Re: Cobbora Coal Project - Independent Groundwater Modelling Review

**PEER REVIEW OF THE COBBORA COAL
PROJECT GROUNDWATER ASSESSMENT**

Report Number: HC2012/5
Date: February 2012

Figure 3.1 Conceptual hydrogeological cross-sections for Talbragar River, Sandy Creek and Laheys Creek

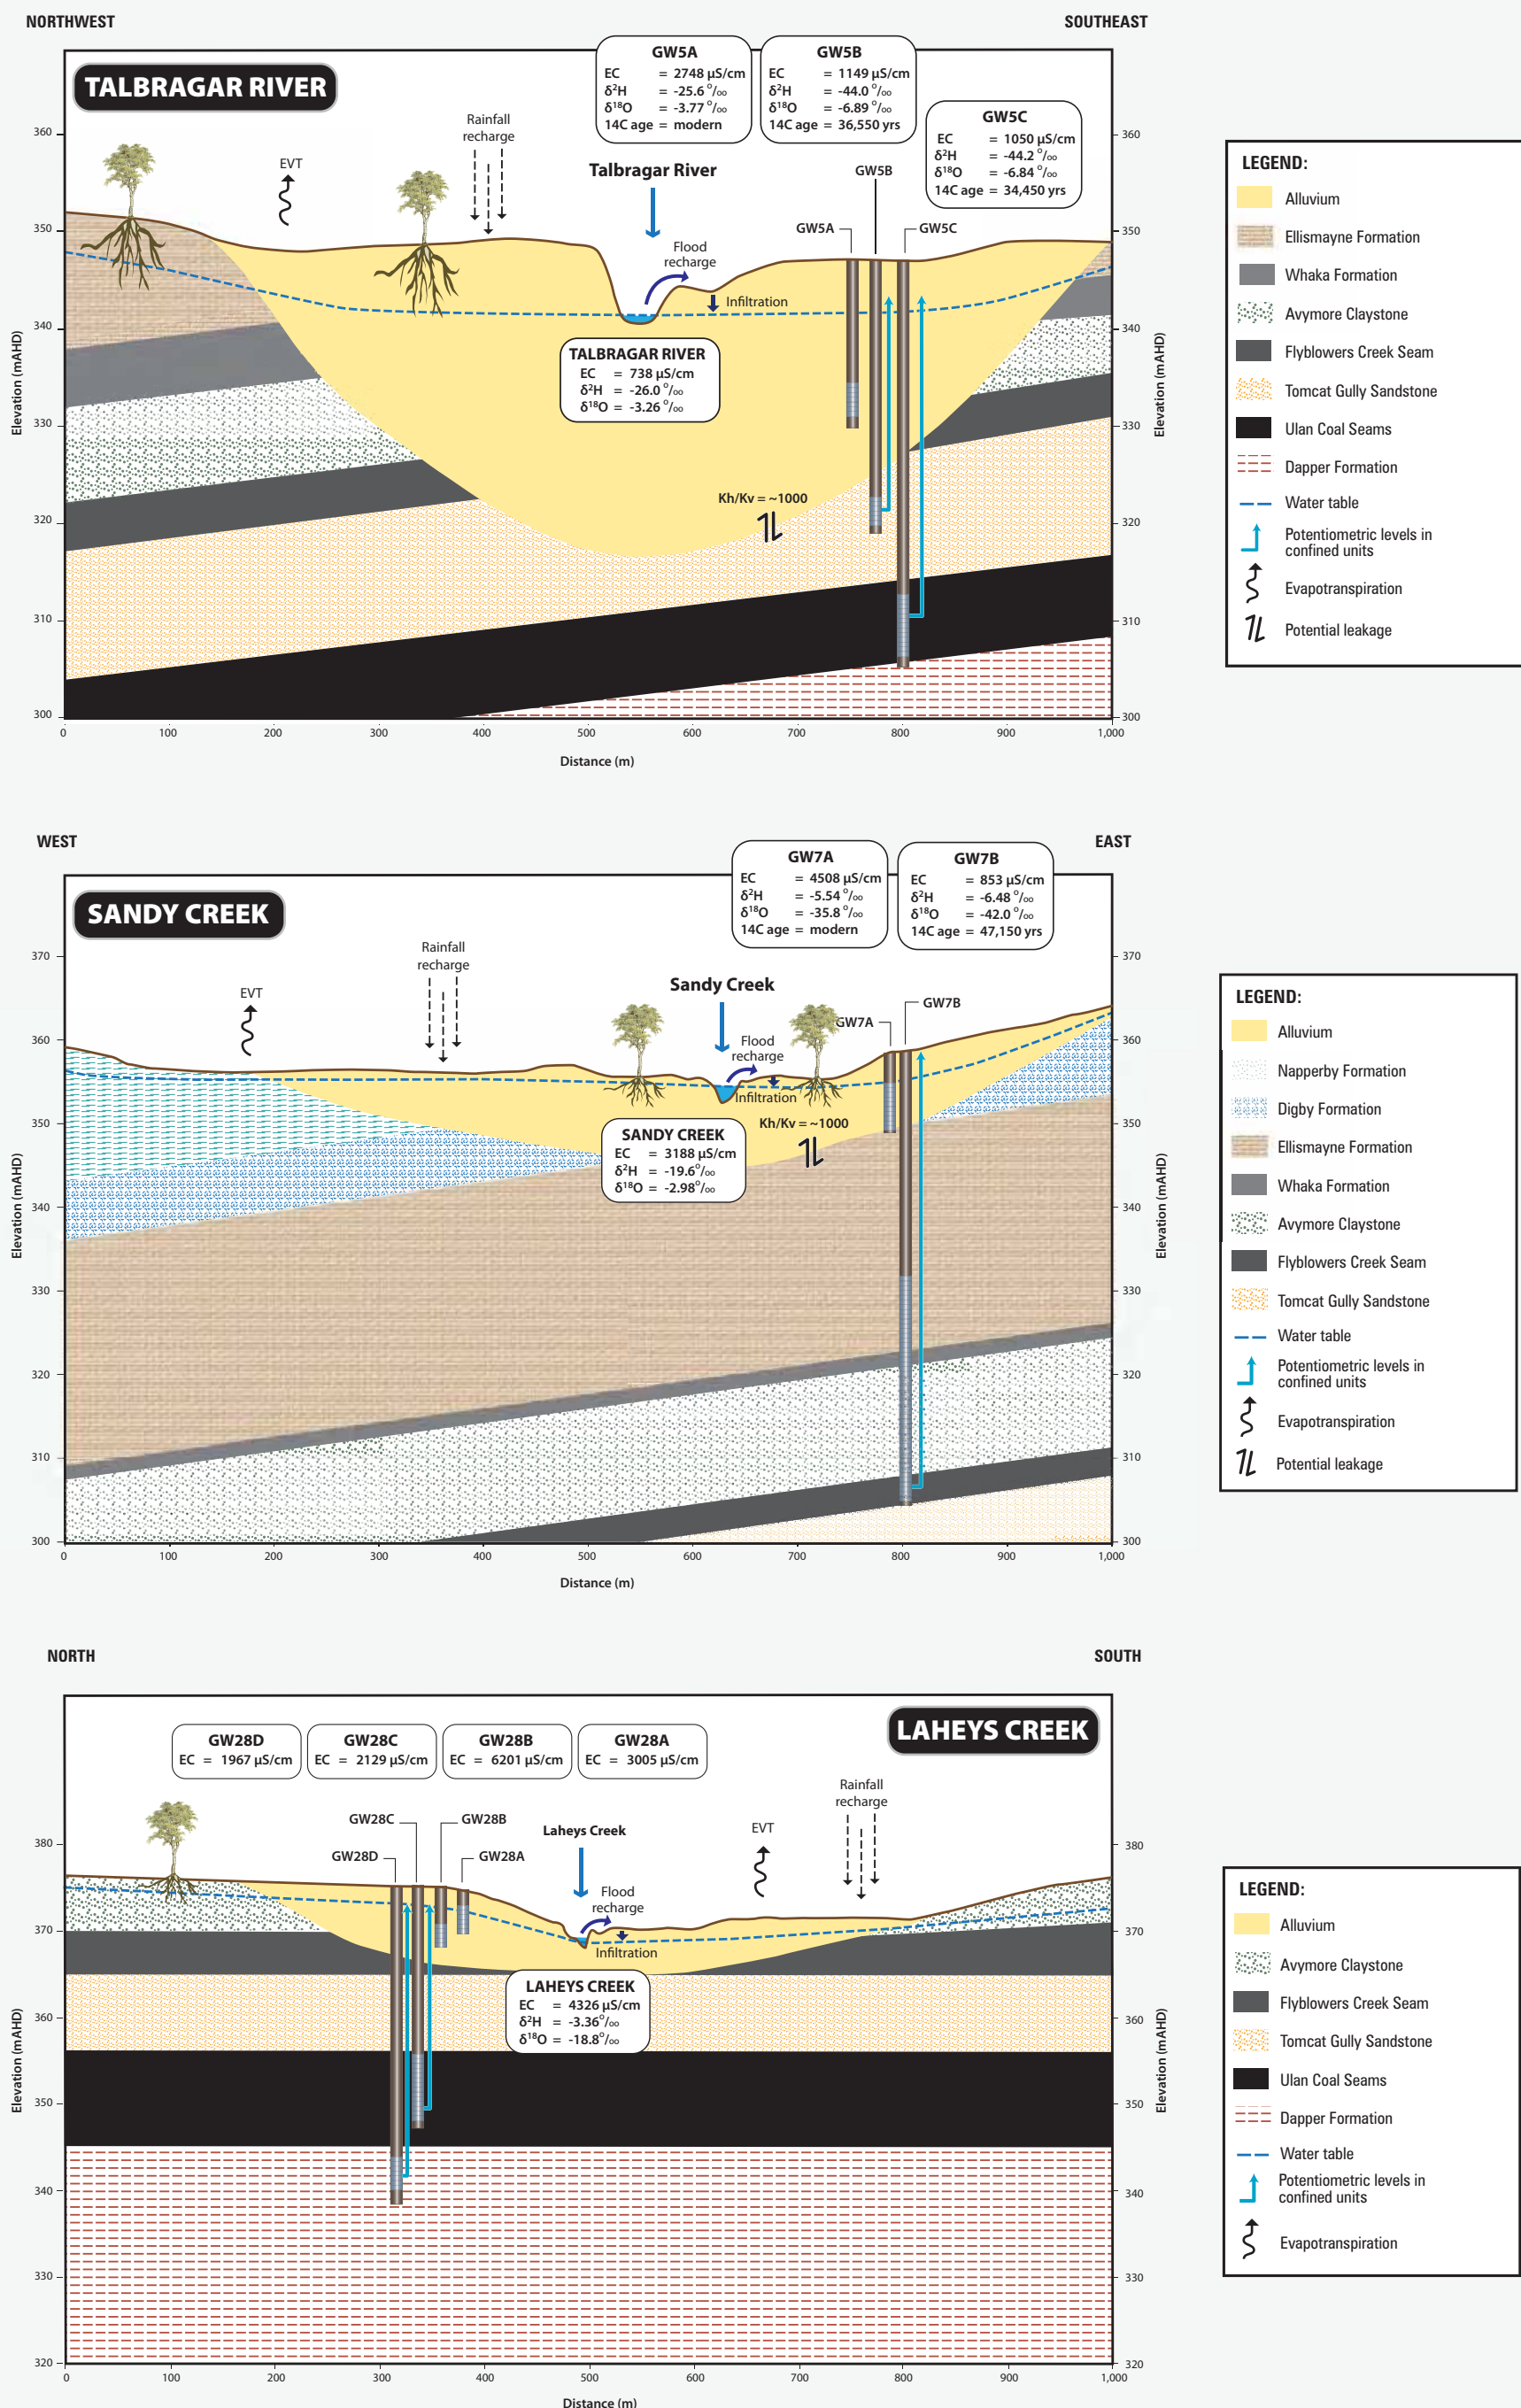
Illustrative pre-mining conceptual model graphics are shown in Figure 5.15 for sections across Talbragar River, Sandy Creek and Laheys Creek. Inclusion of a modified section for post-mining conditions would be informative to the reader to indicate how groundwater flow directions will change. The same or similar diagram should appear in Document #2; although referenced, it was not included in the report at the time of review. There are conceptual cross-sections in Section 2 of Document #2, but they are meant to show geological complexity rather than recharge-discharge processes.

Figure 4.2 Groundwater level contours

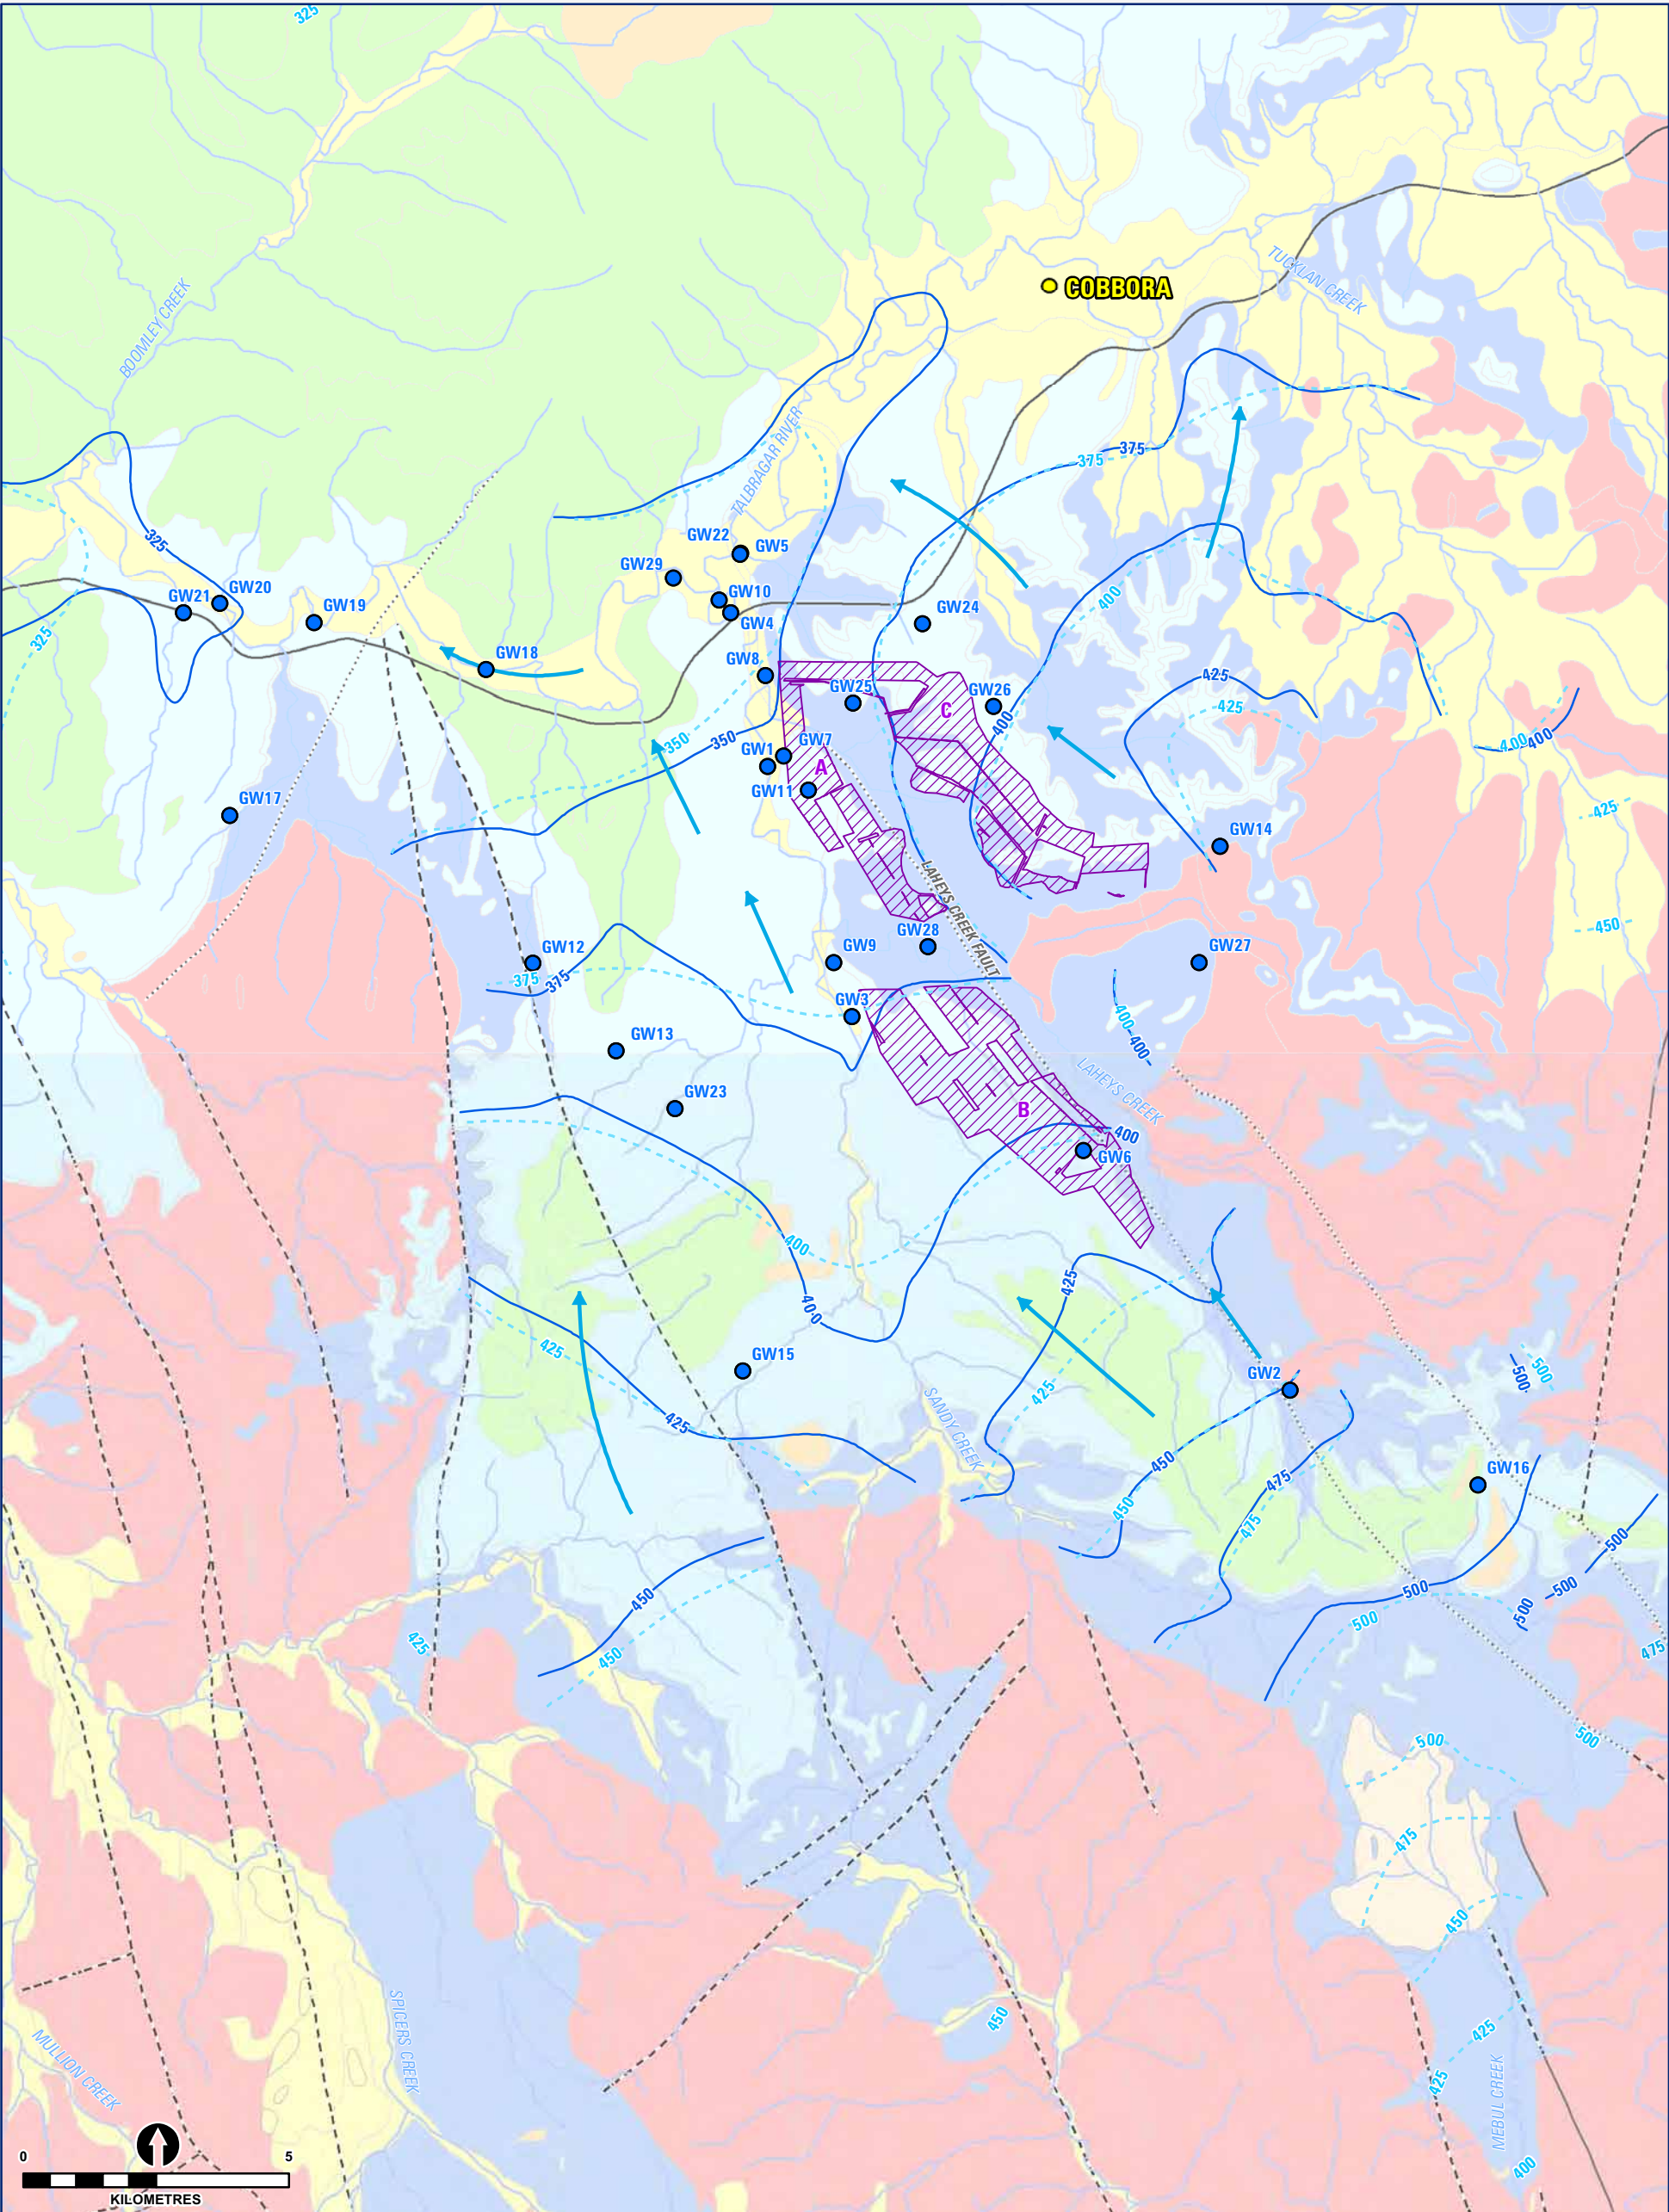
Groundwater head contours and flow directions are established for the water table and the Dapper Formation, showing clearly the potential for artesian conditions along Sandy Creek and the Talbragar River. This diagram of field contours is misrepresented in Document #2 as a map of simulated contours.

Several lines of evidence are provided in Document #2 in support of steady-state calibration in the form of a scatter plot and RMS performance statistics. The steady-state performance is measured at 2.7 %RMS and 4.4mRMS, which is satisfactory. To demonstrate good spatial calibration, a simulated groundwater level map should have been offered for comparison with the observed/interpolated contour map.
